Liverpool Health & Academic Precinct
MSCP SSD-10388

28th of September 2021

SSD MODIFICATION

LIST OF PROPOSED MODIFICATIONS

PROJECT NO.
21807
STATUS
SSDA AMENDMENT
DRAWING NO.
A-SSDA-MSCP-07
ISSUE
08

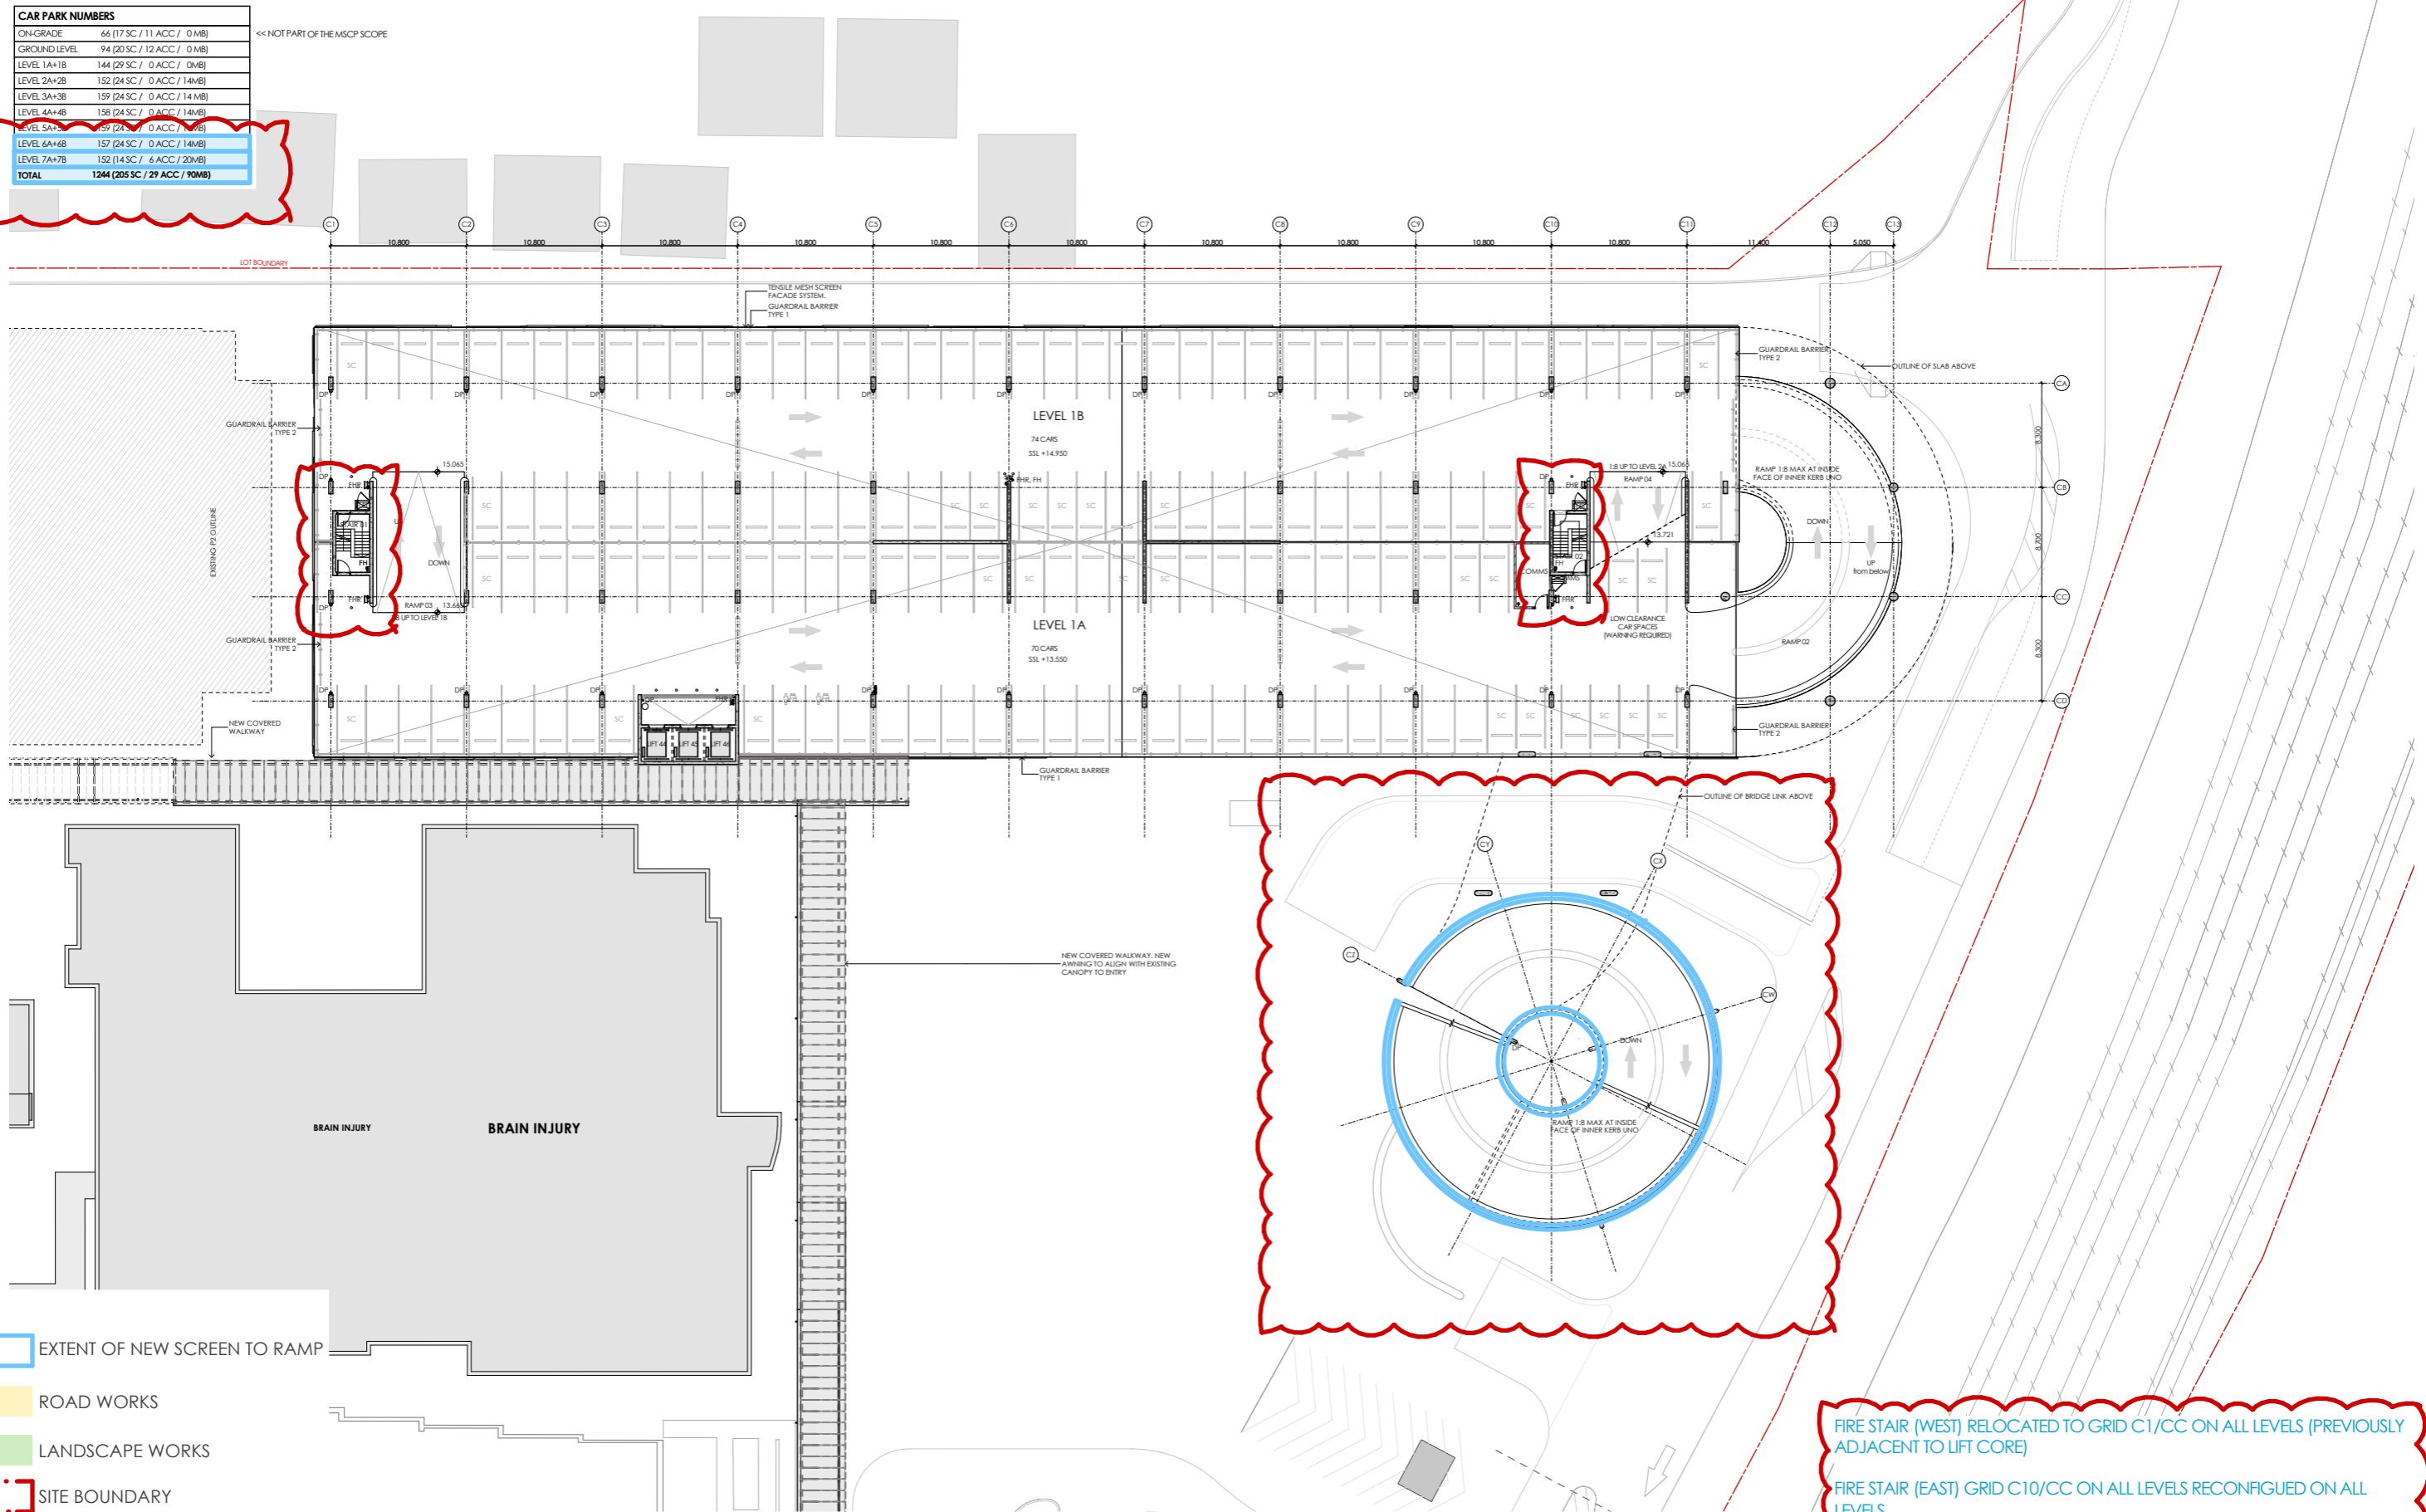
- + Ground floor bicycle parking relocated to grid C4/CD
Reason: Better planning outcome
- + Ground floor Main Switch Room relocated to grid C5/Cd
Reason: Better planning outcome

- + Fire stair (West) relocated to grid C1/CC on all levels (previously adjacent to lift core)
Reason: Better planning outcome
- + Fire stair (east) at grid c10/cc reconfigured on all levels
Reason: Better planning outcome and access to fire stair

PROJECT NO.	DRAWING NO.	ISSUE
21807	A-SSDA-MSCP-09	08
STATUS		
SSDA AMENDMENT

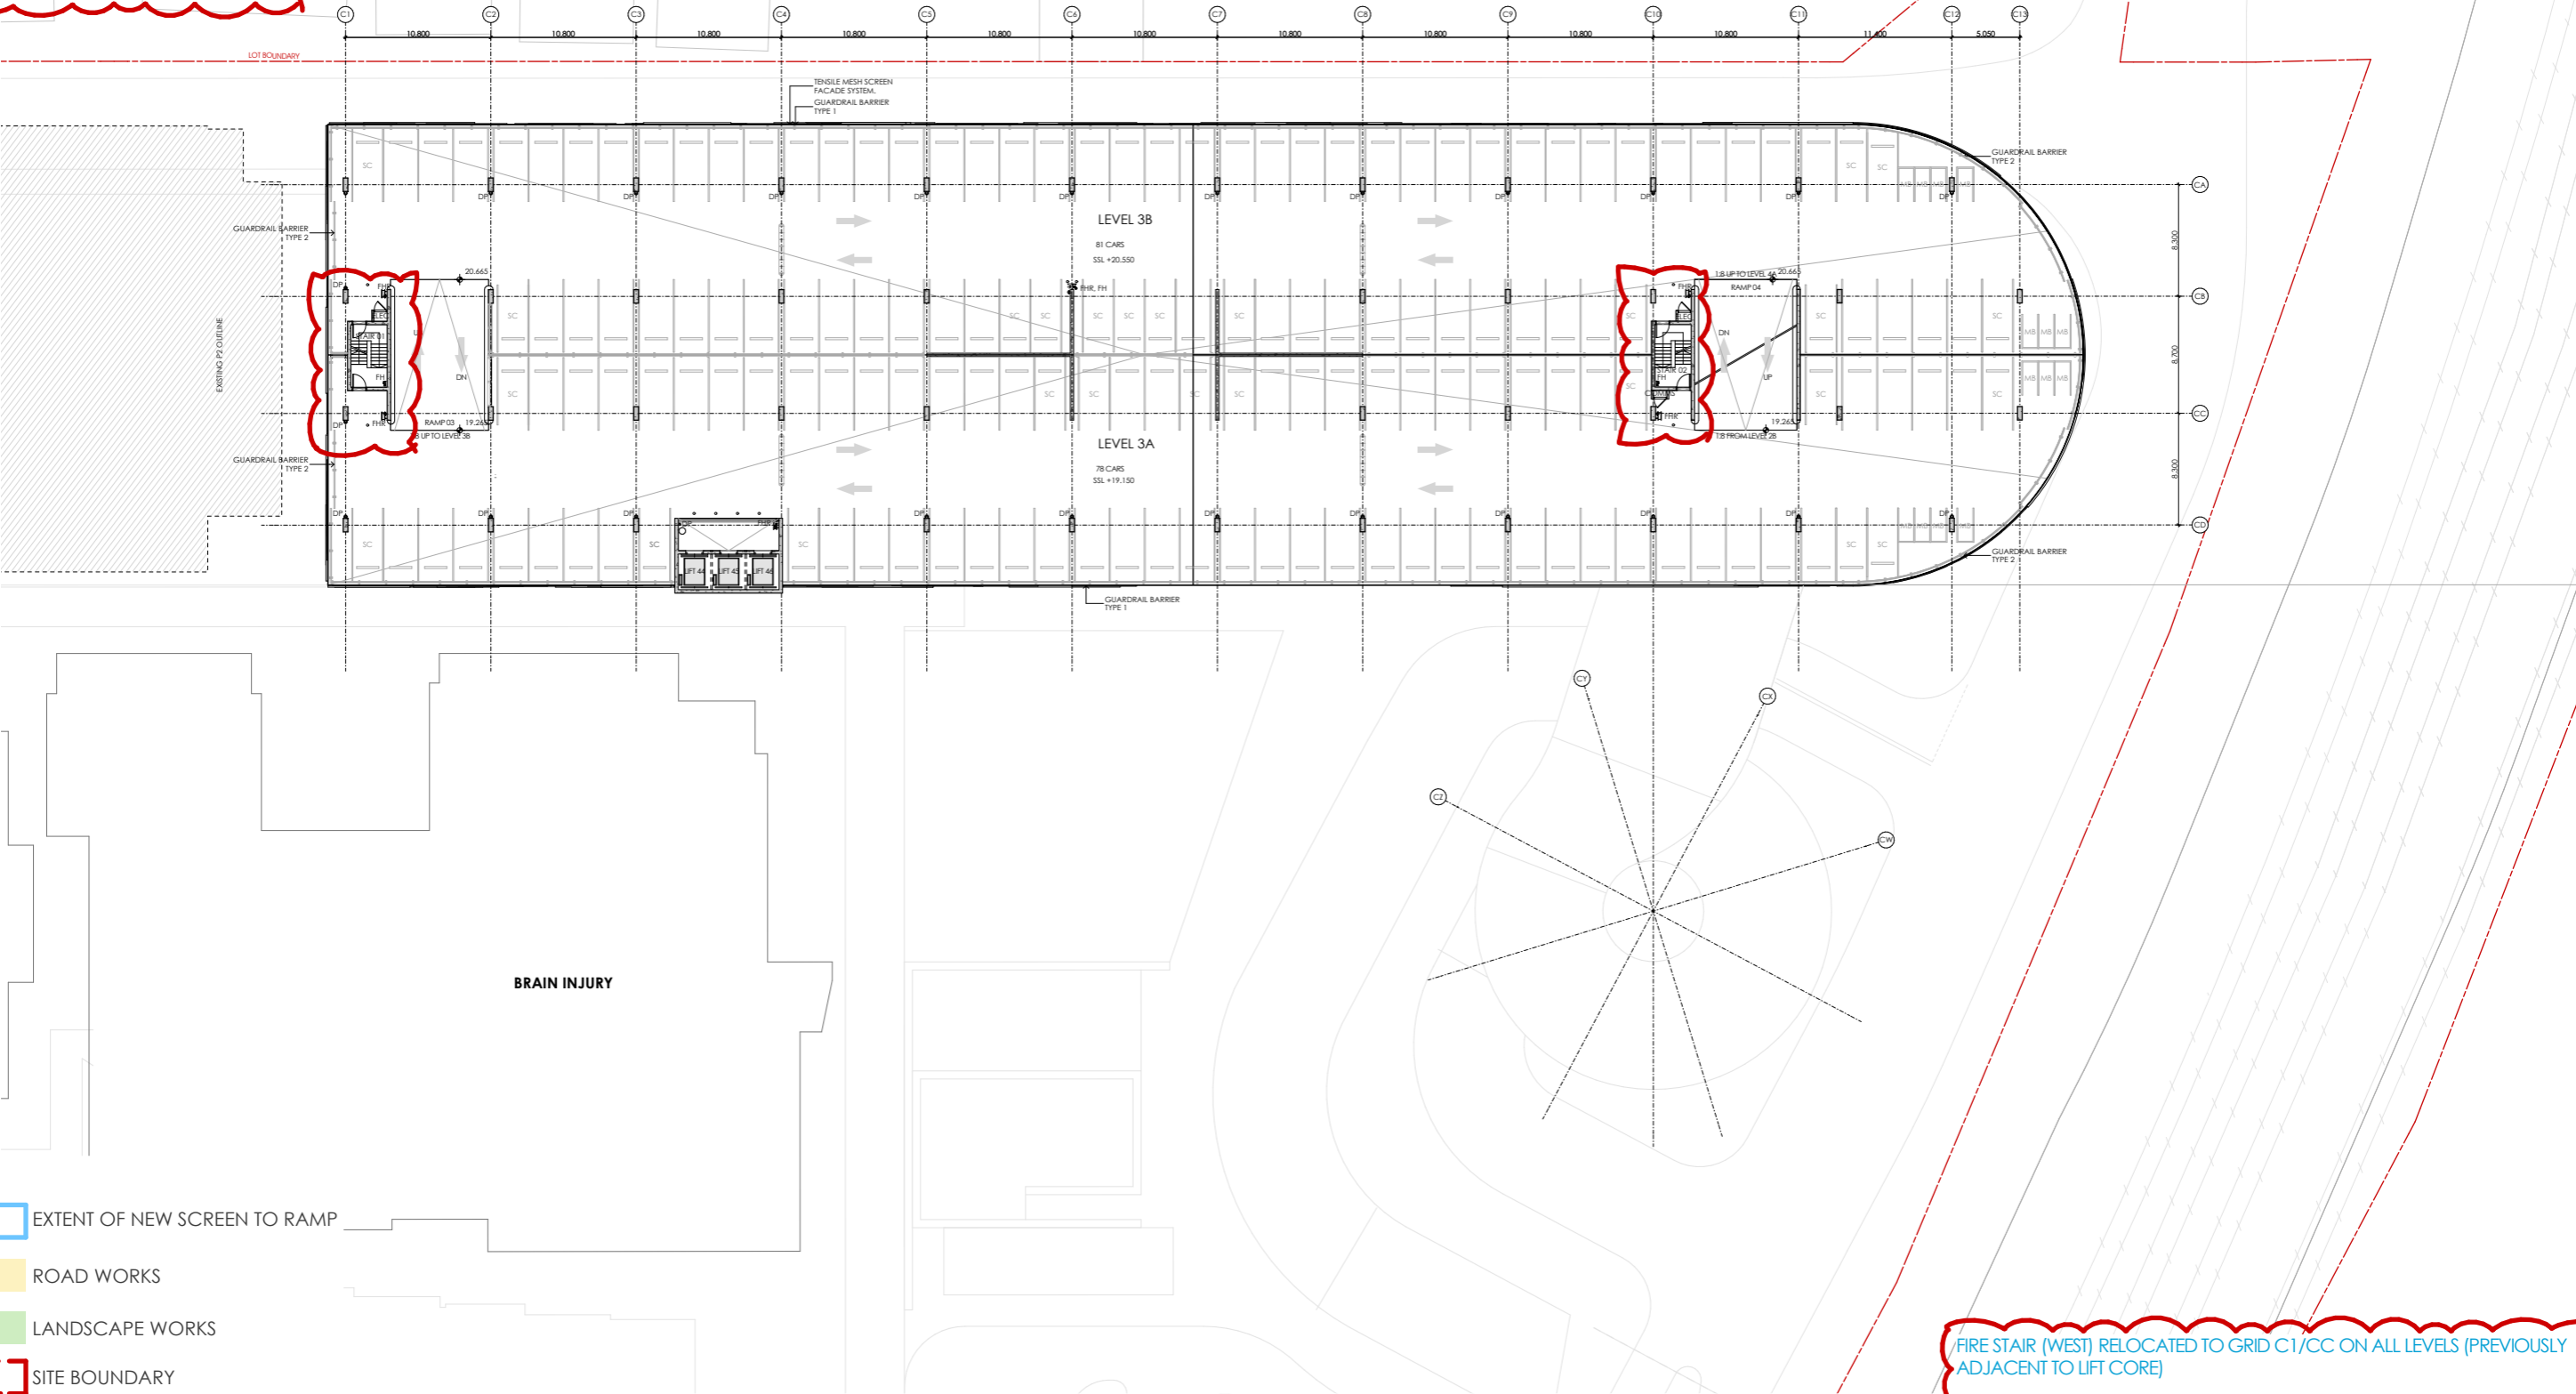
- + Level 2 entry driveway reconfigured to allow for two vehicle entry lanes and two vehicle exit lanes
Reason: Further developments in the design in conjunction with traffic engineer

PROJECT NO.	DRAWING NO.	ISSUE
21807	A-SSDA-MSCP-14	08

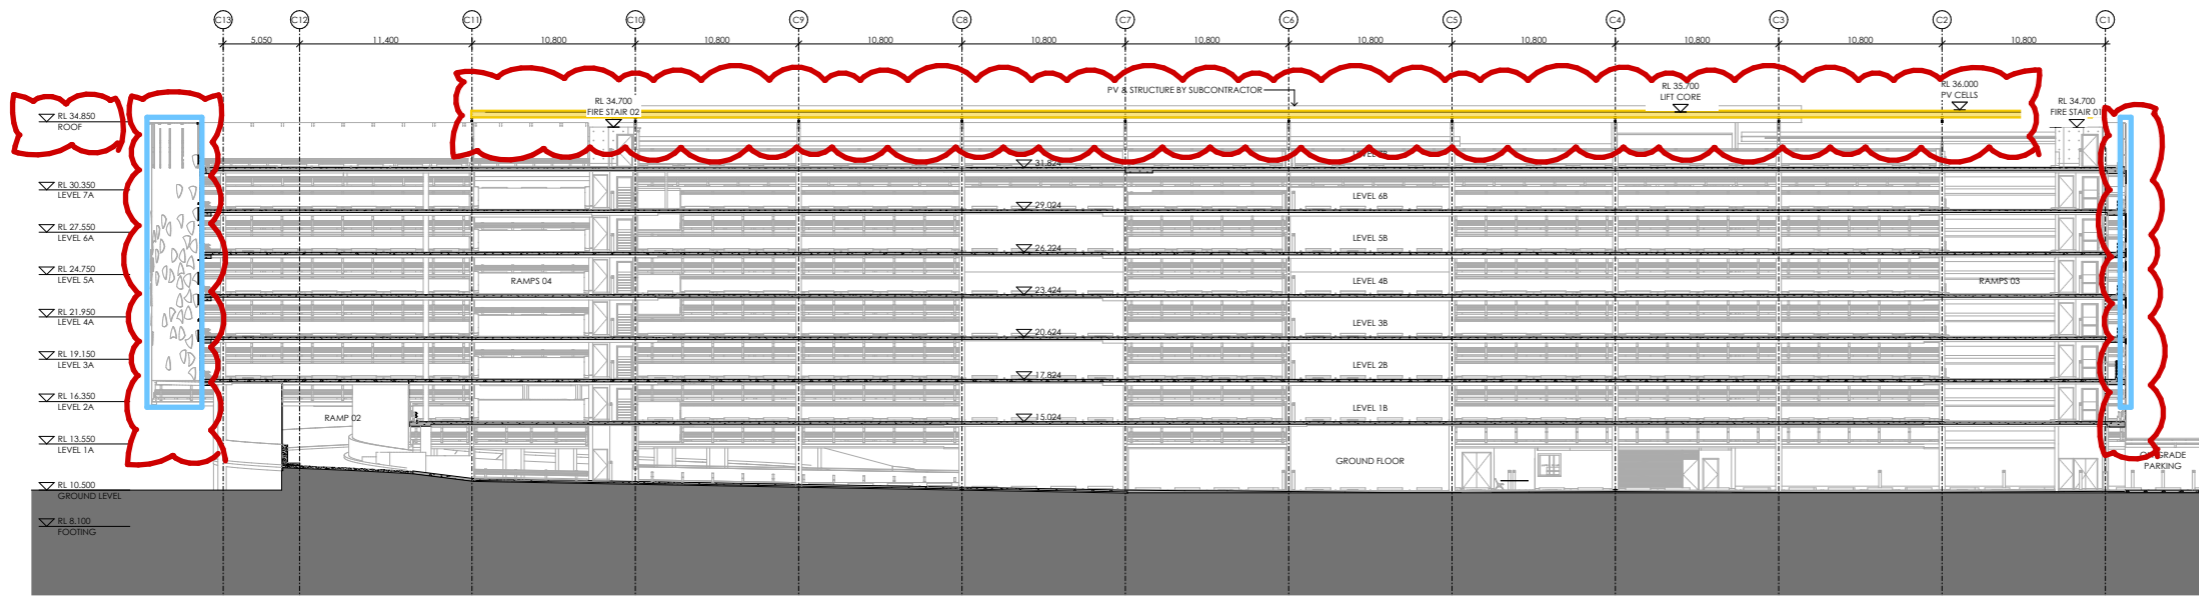
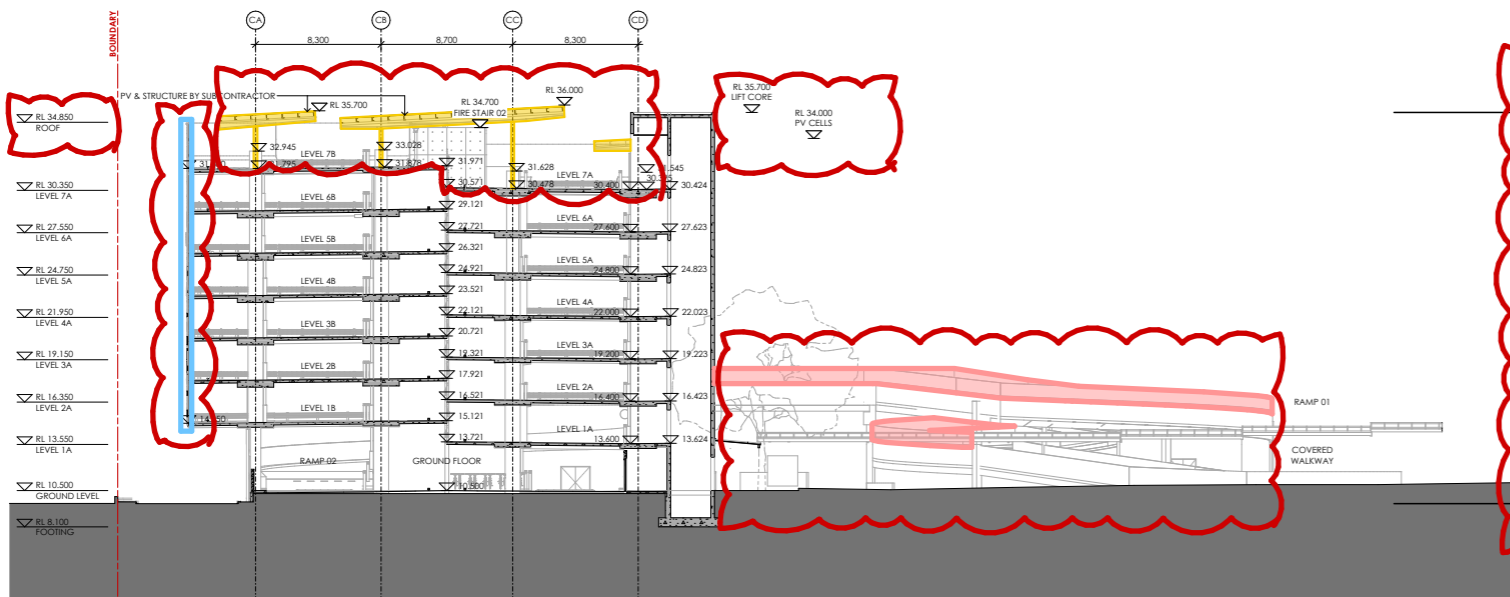
- + Increased roof top parapet safety screen height (500mm increase to RL34.850)
Reason: to provide additional safety and a higher level of fall protection

- + Incorporation of a new artwork in place of the previous façade design
Reason: incorporation of an artwork in accordance with previous consultation undertaken and SSD Clause D26 relating to public art.
